Final Report - Corrections Required **Application No. SUBD-26-0037**

Description : Single Family residential north of New Life Drive in the Flying Horse Masterplan.

Document Filename : FP Creekridge at Flying Horse Filing No. 1 V2.pdf

SHEET 1 OF 6
APRIL 23, 2026
JOB NO. 1171.78
CREEKRIDGE FILING NO. 1

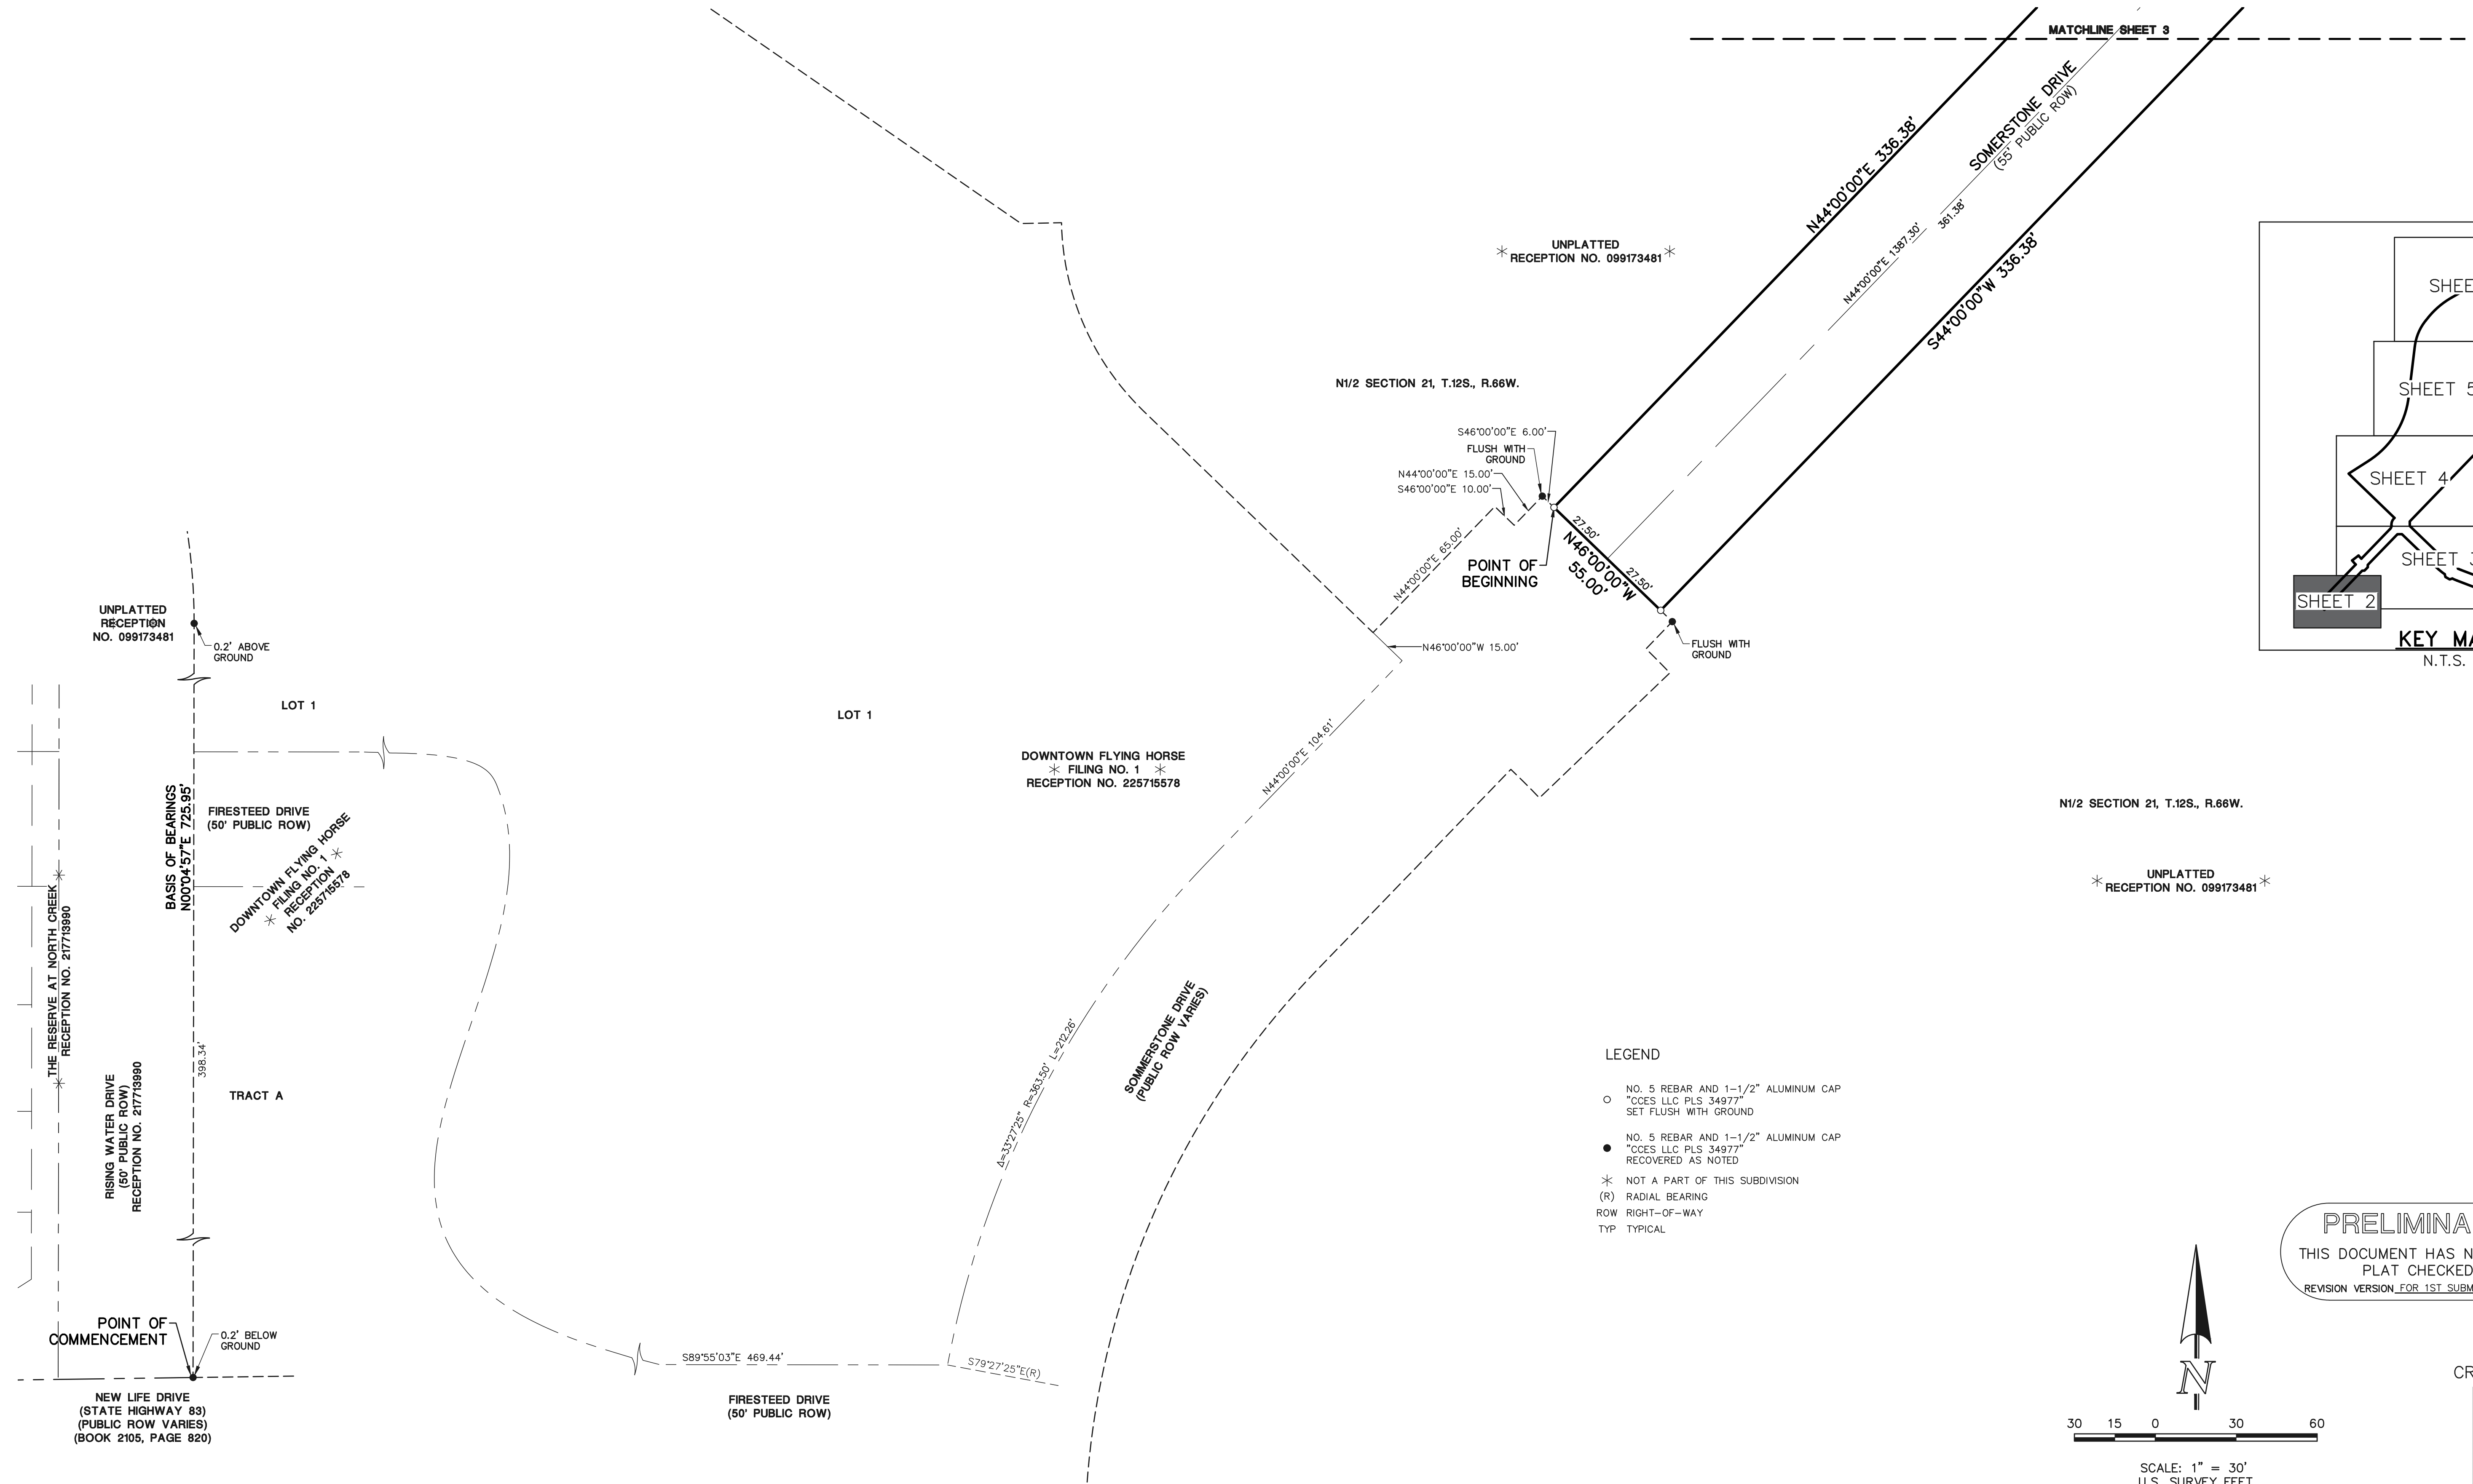
Please provide just a signature line for Mr. Stimple.

SHEET 2 OF 6
APRIL 23, 2026
JOB NO. 1171.78
CREEKRIDGE FILING NO. 1

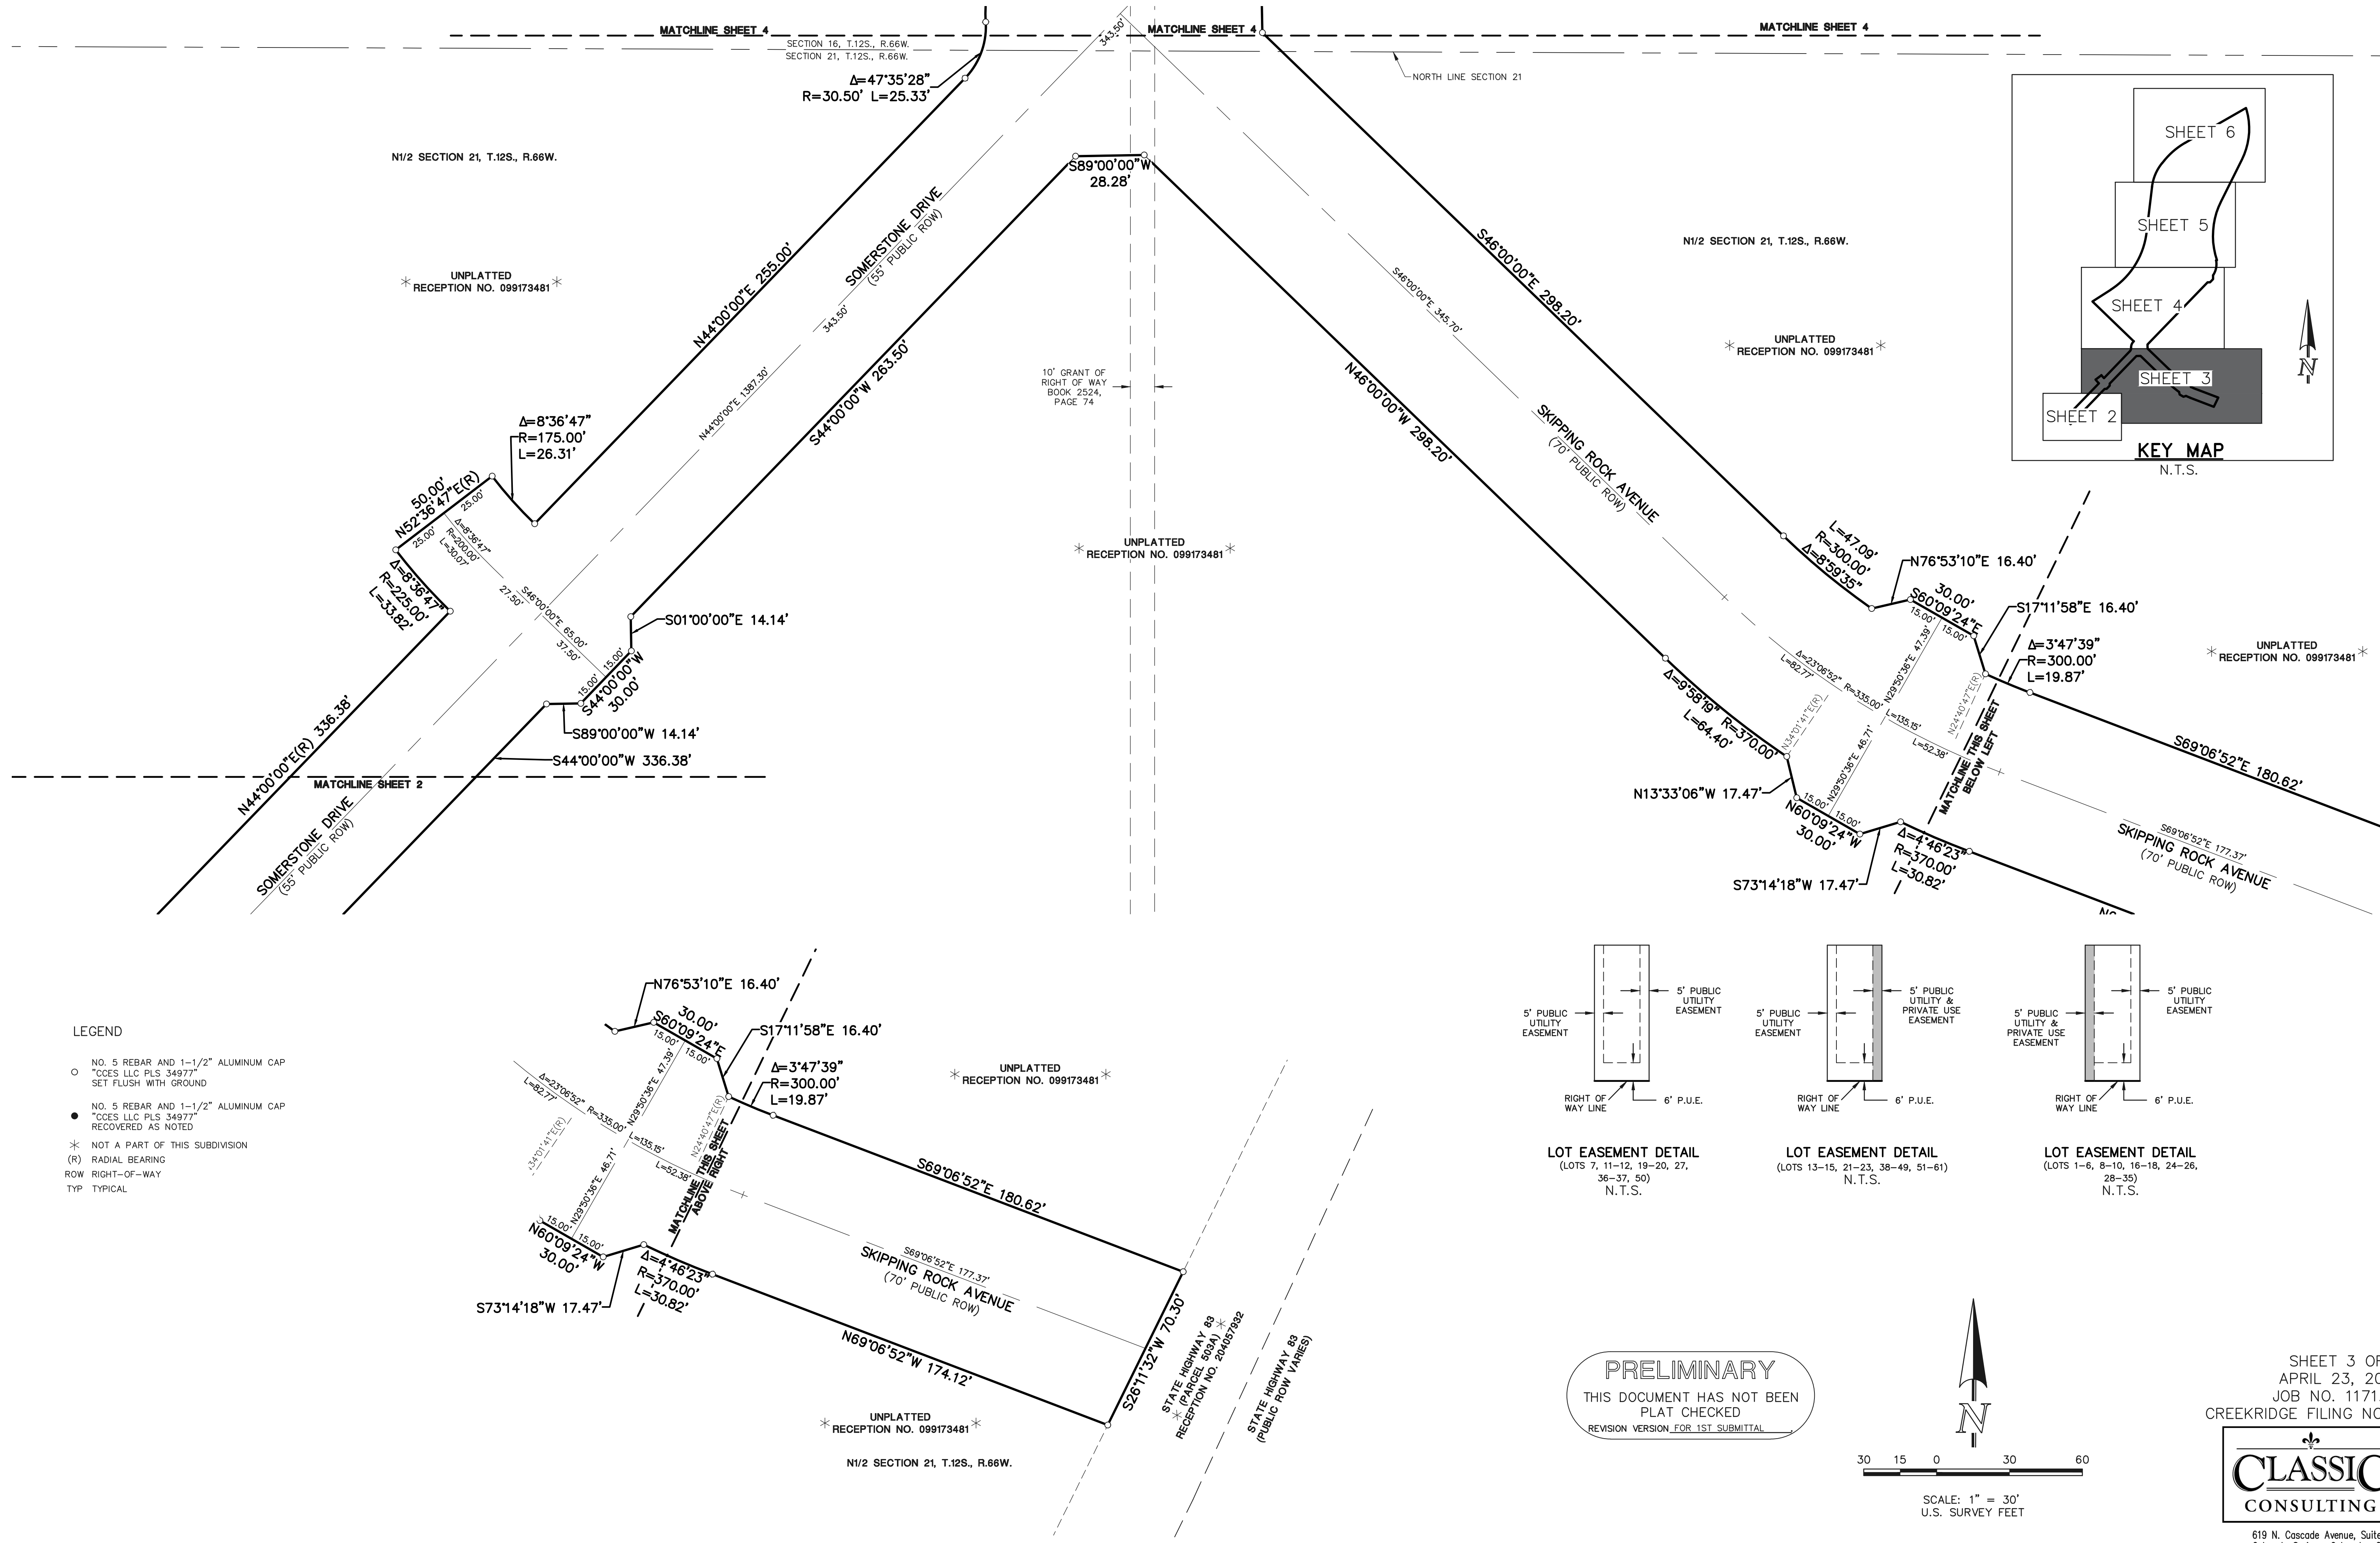
please check/revise 398.35' depicted sheet 2
